ENGLISH HERITAGE
NORTH WEST REGION

Our ref: P00105557

Notifications under Circular 01/2001 & GDPO 1995
ENGLISH MARTYRS CHURCH, THE SANDS, WHALLEY, LANCASHIRE, BB7 9TN
Application No 3/2011/0408

Client	Date
SALFORD RC DIOCESAN TRUSTEES REG	April 2011
Project Title	Scale
ENGLISH MARTYRS RC CHURCH, WHALLEY	1:500 @ A3
REFURBISHMENT	
Drawing Title	Dwg No
EXISTING & PROPOSED SITE PLANS	10106 - 06P

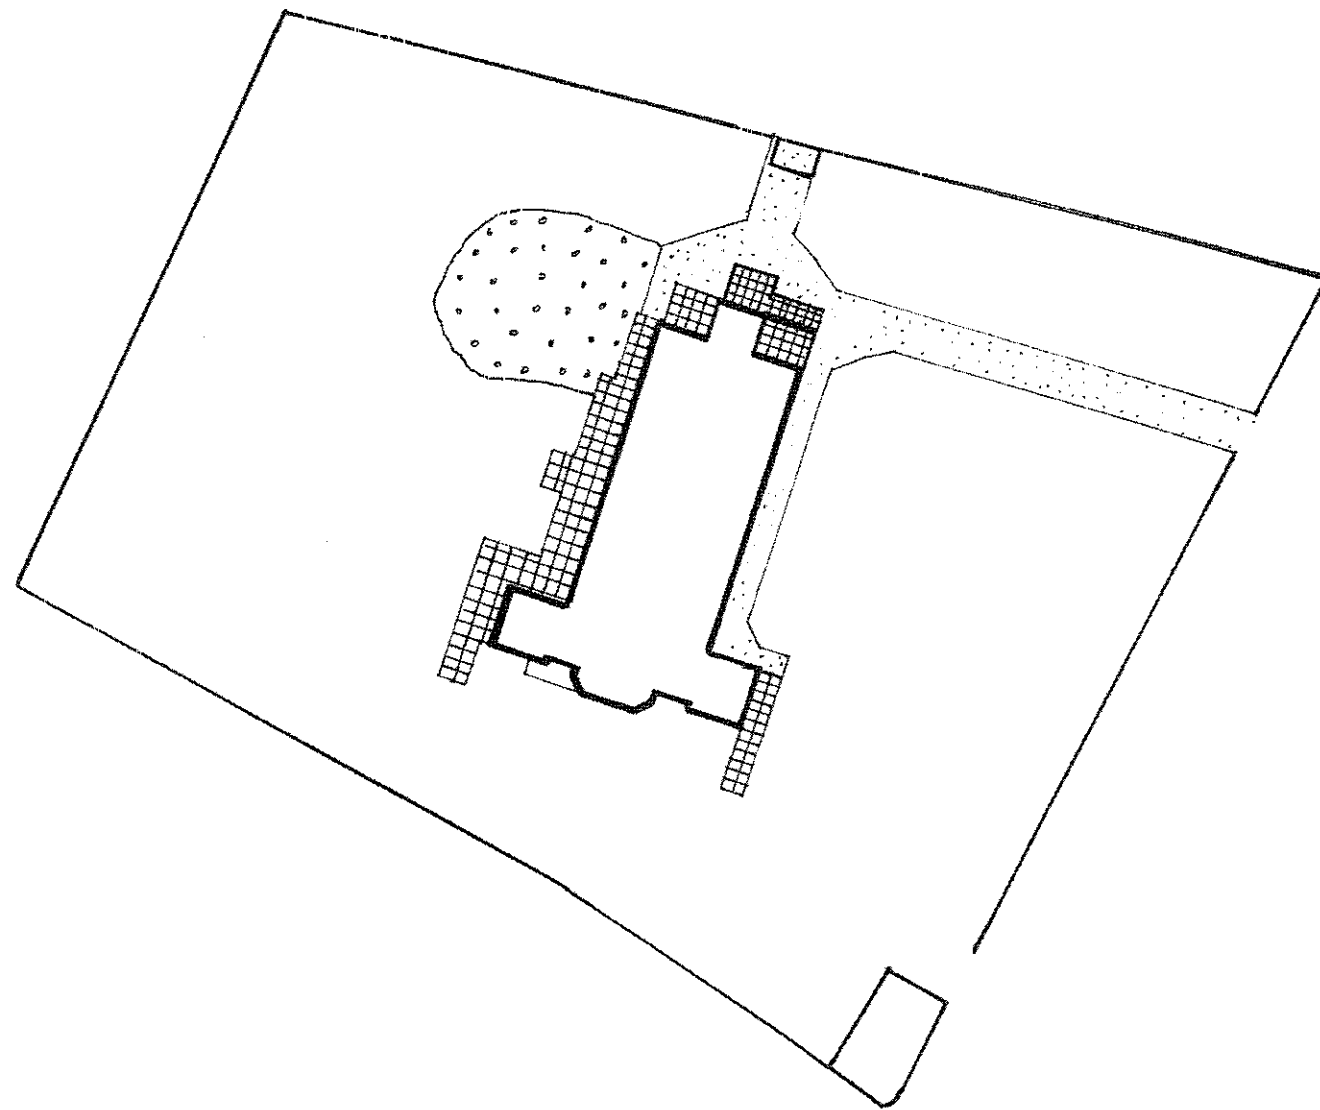
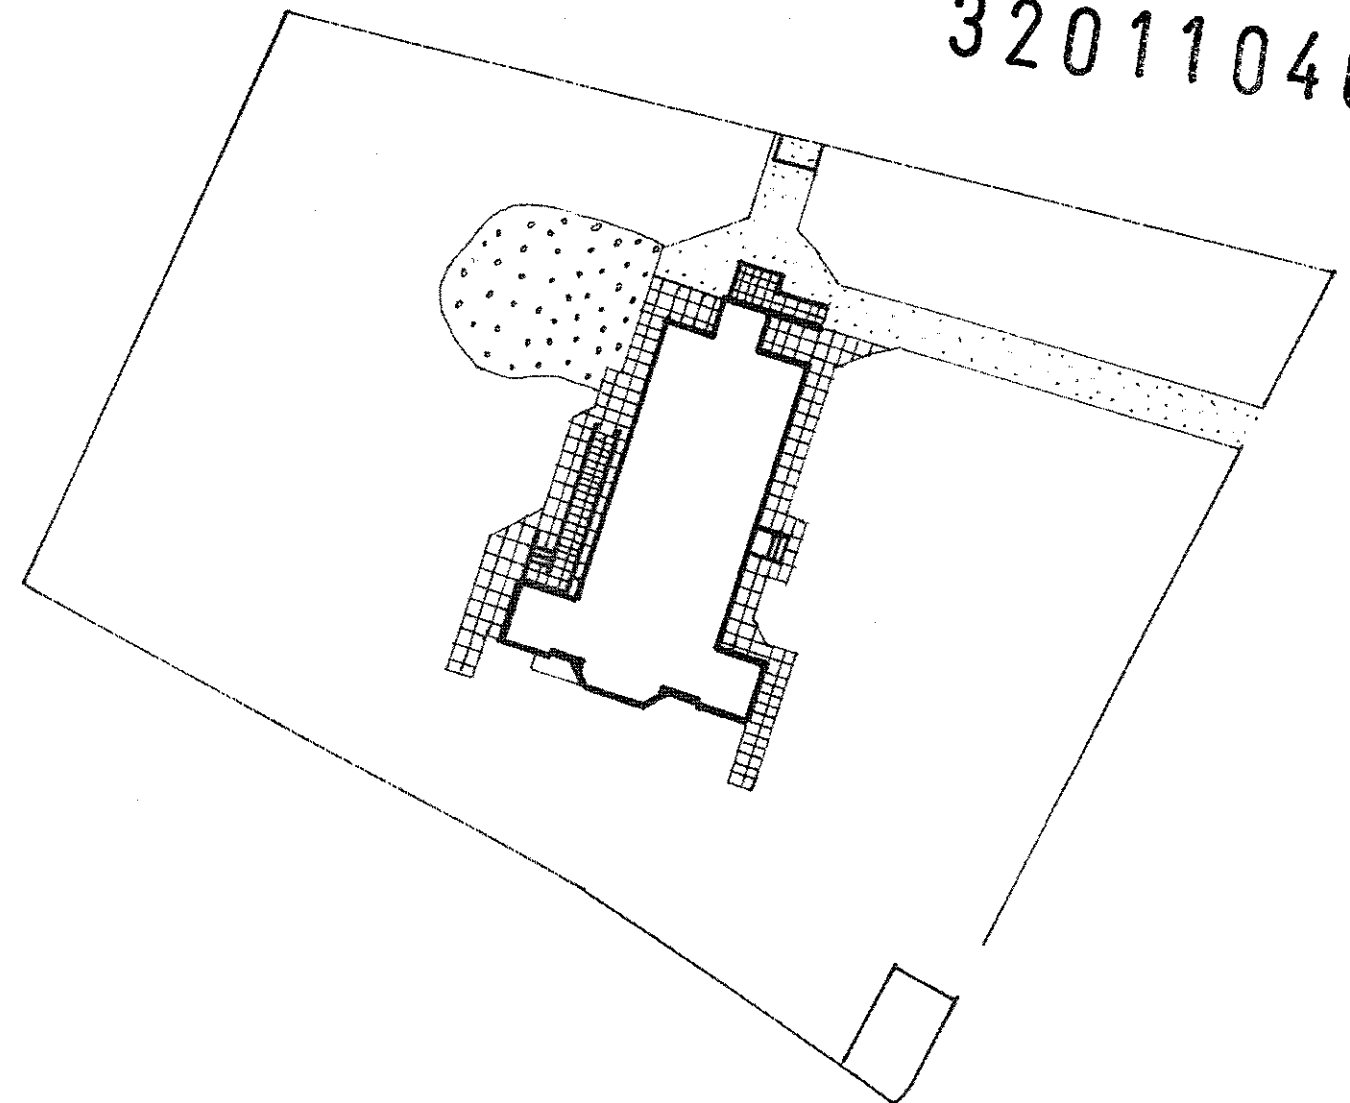
English Heritage has no issues with the proposals described in this application as there is no impact upon the scheduled monument. However, we note that the drawing shows a proposed new drain. If this is part of the scheme, archaeological supervision of the excavation would be advisable. This is a matter for the applicant to discuss with Peter Iles at Lancashire County Council (peter.iles@lancashire.gov.uk)
